From: Anita Gardner
Sent: 04 December 2018 17:26
To: Lynnyrd Wolfe
Subject: FW: FG/171/18/DOC - Honda Garage Premises, Littlehampton Road,

Environmental Health: Application for discharge of conditions. Further information required.

Honda Worthing 11-07-18 EXT REV 0

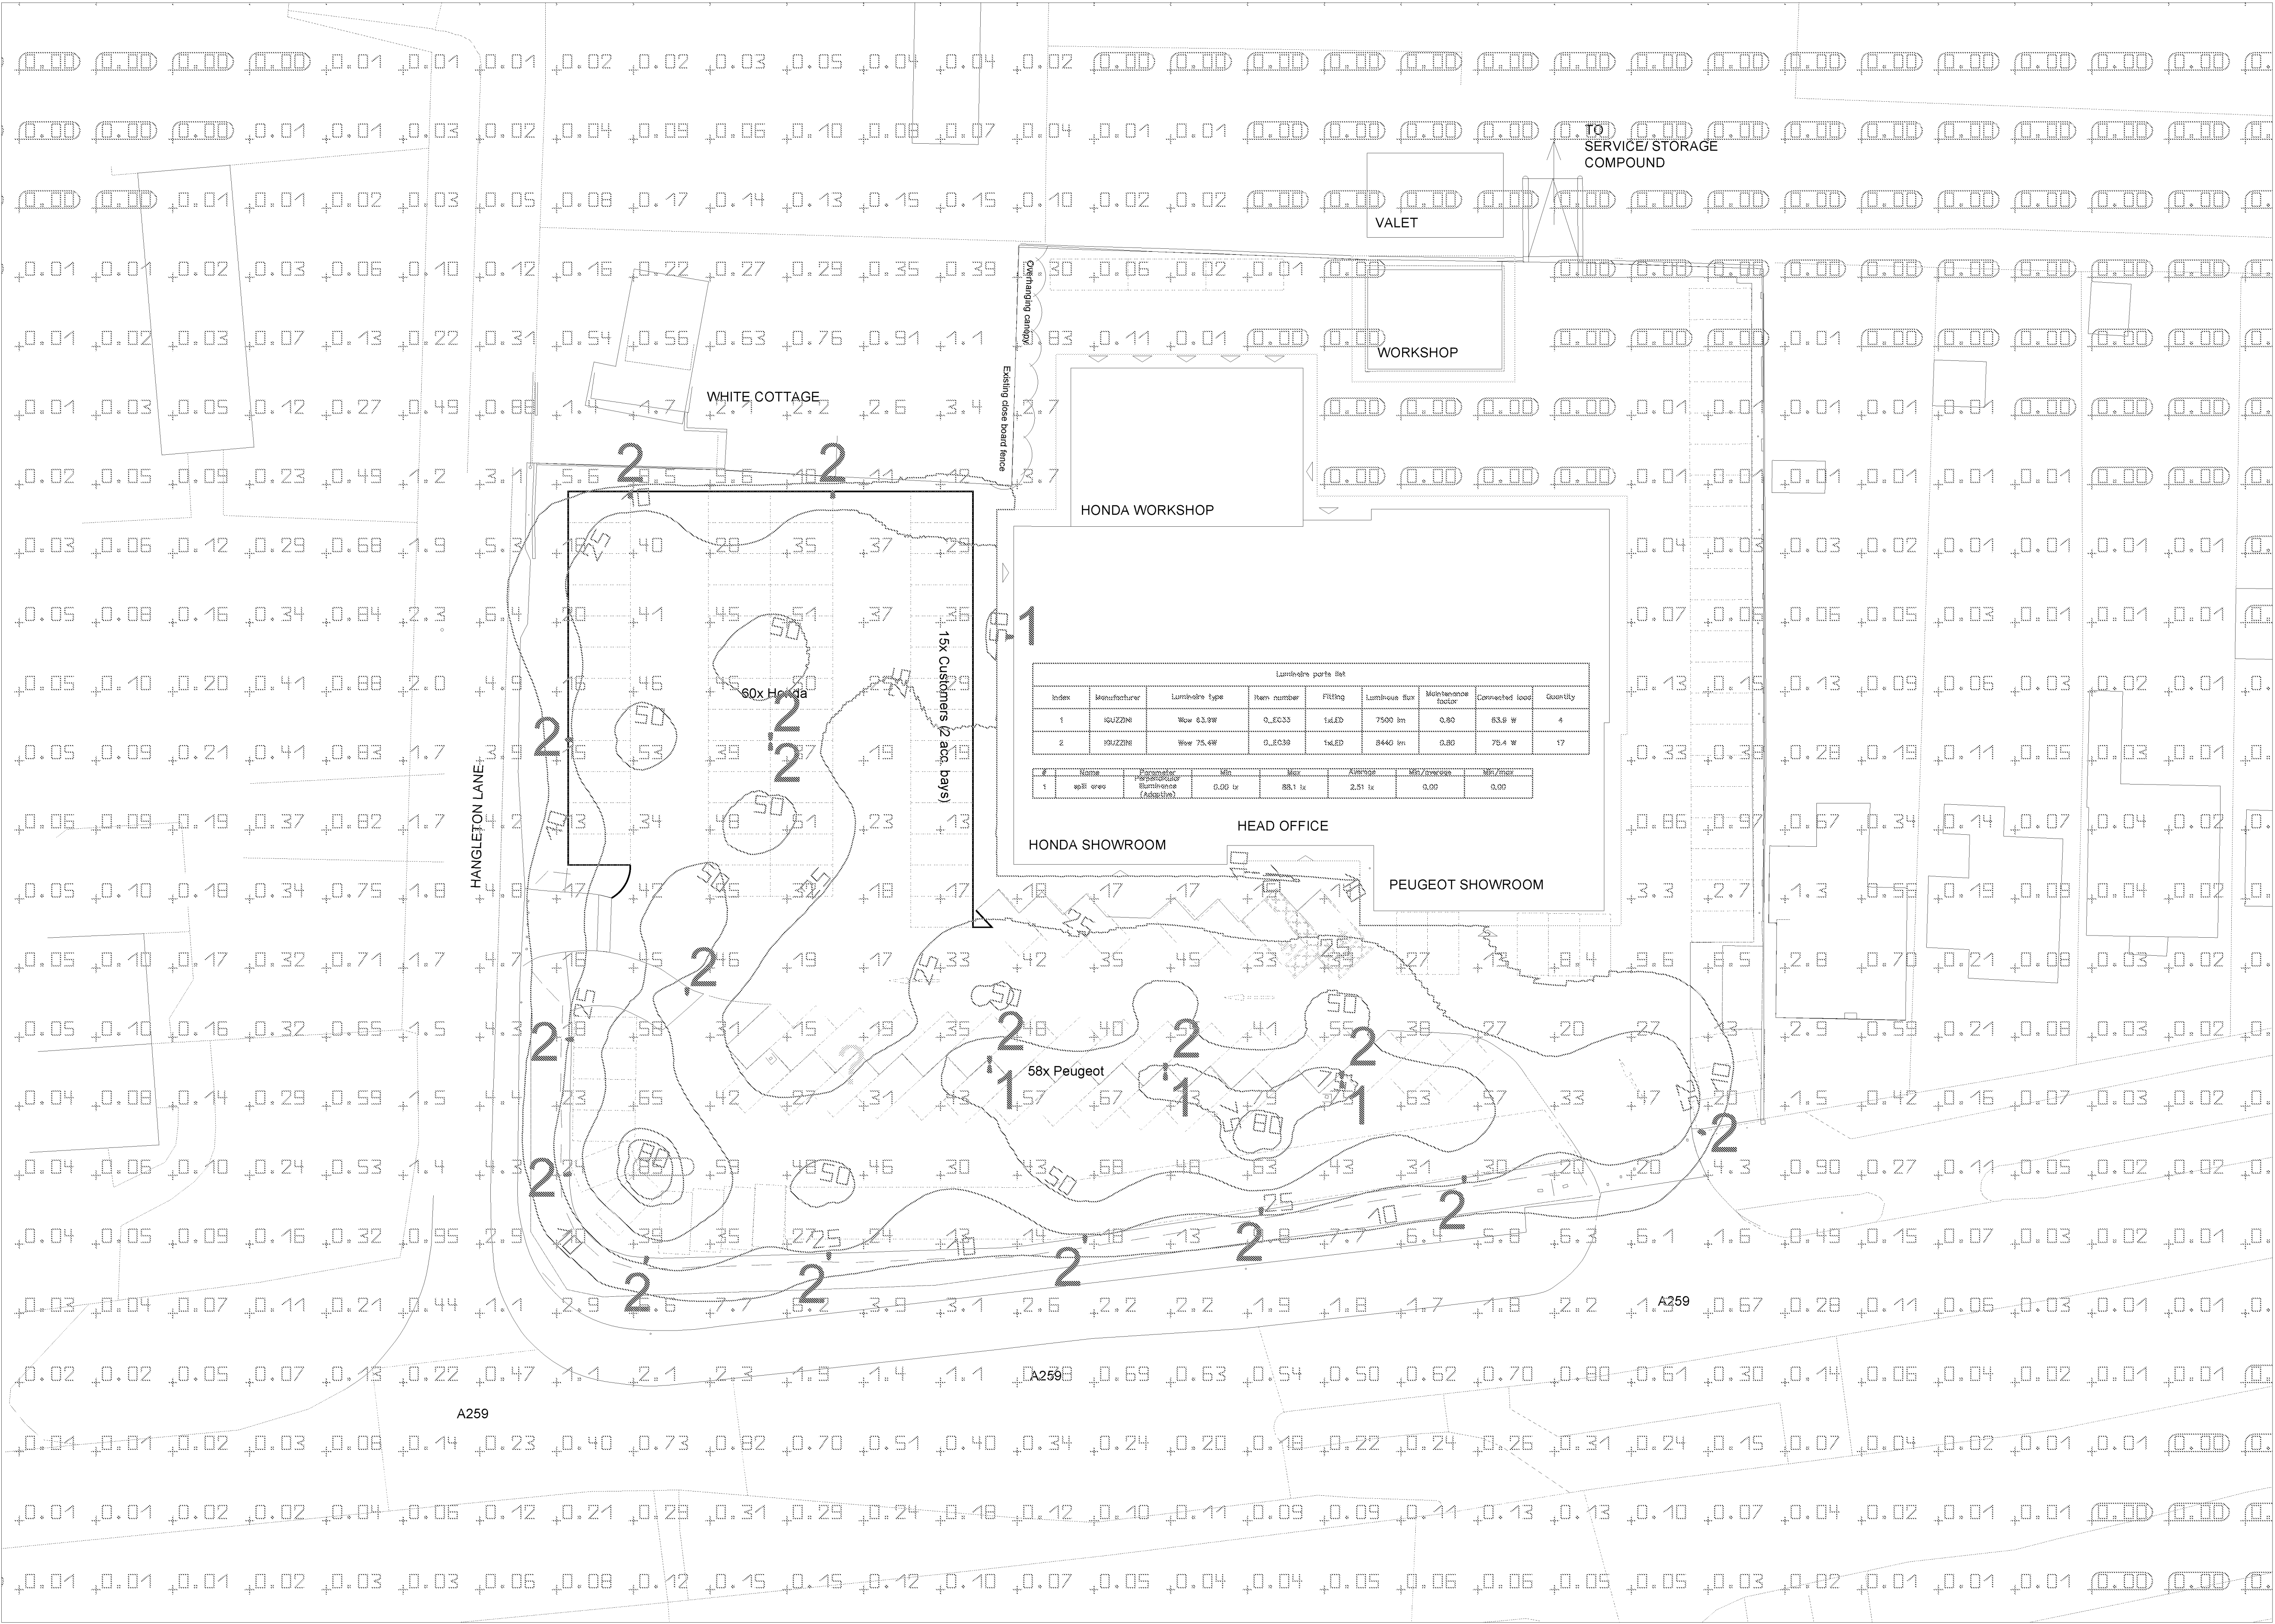
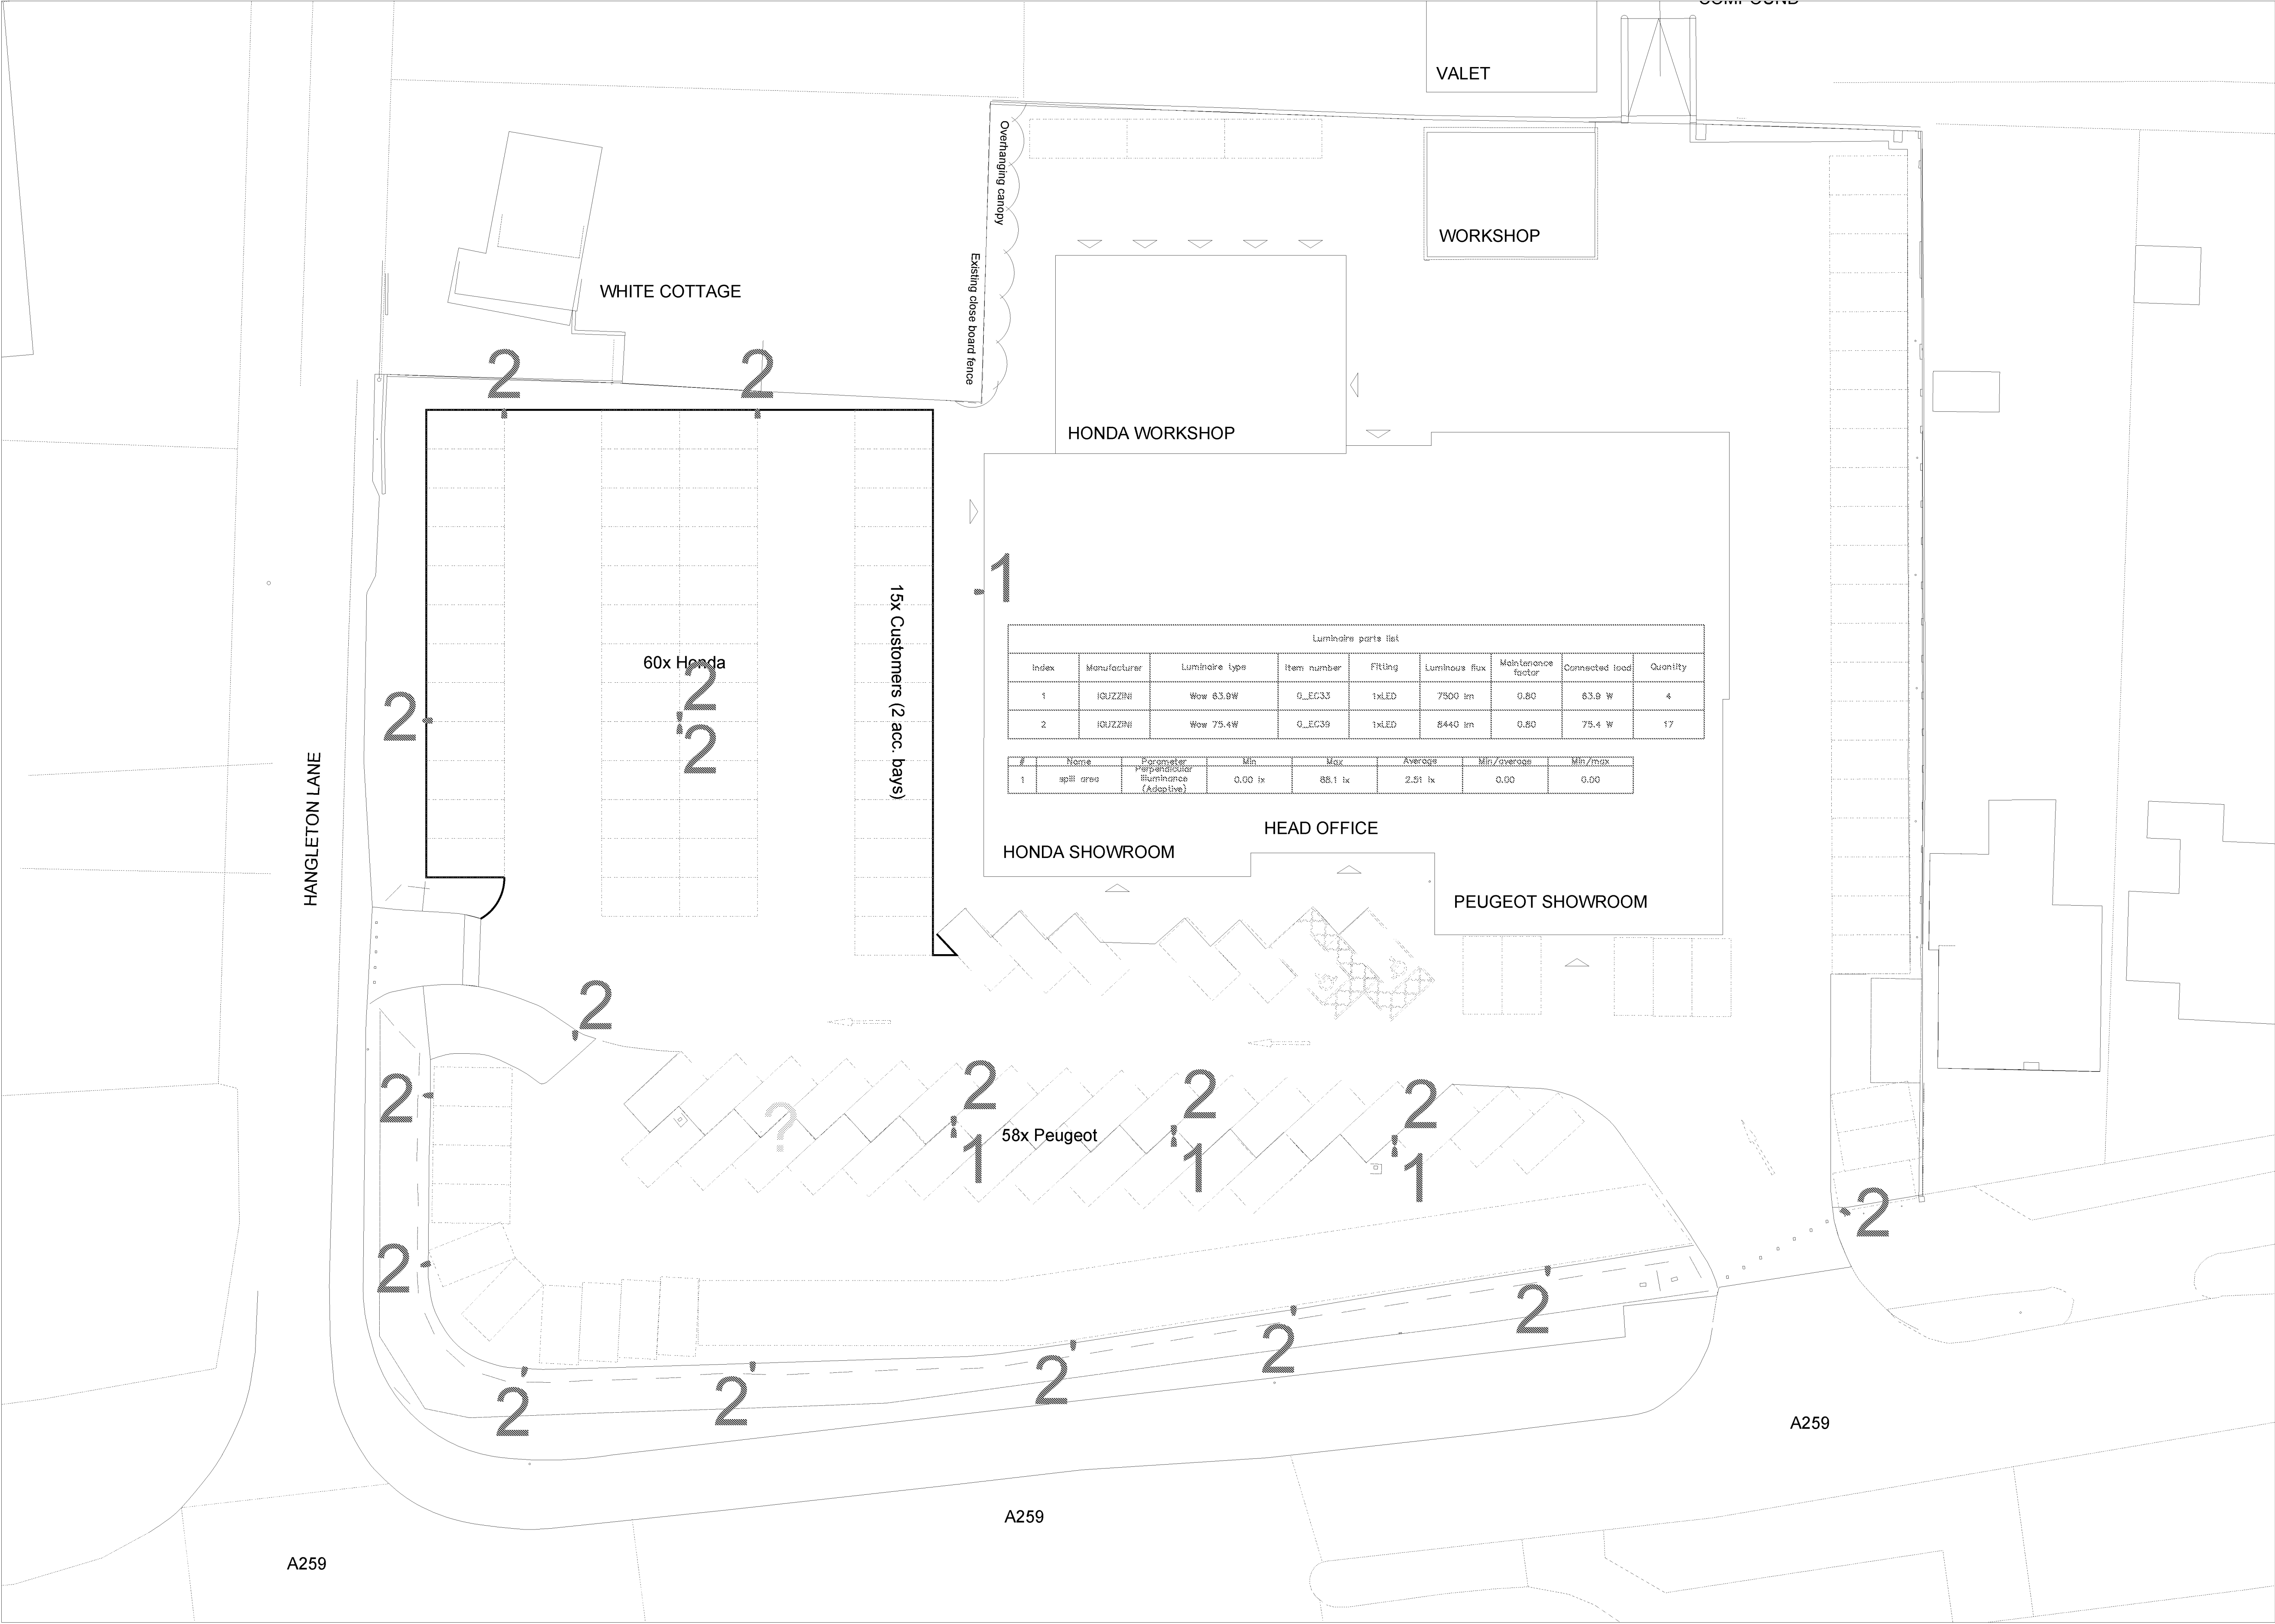
Lighting Plan: Lower level lighting, specified as 'Type 1' to be provided to areas proximal to sensitive receptors and to the north of the site in order to prevent detriment to the amenity of these properties and South Downs National Park.
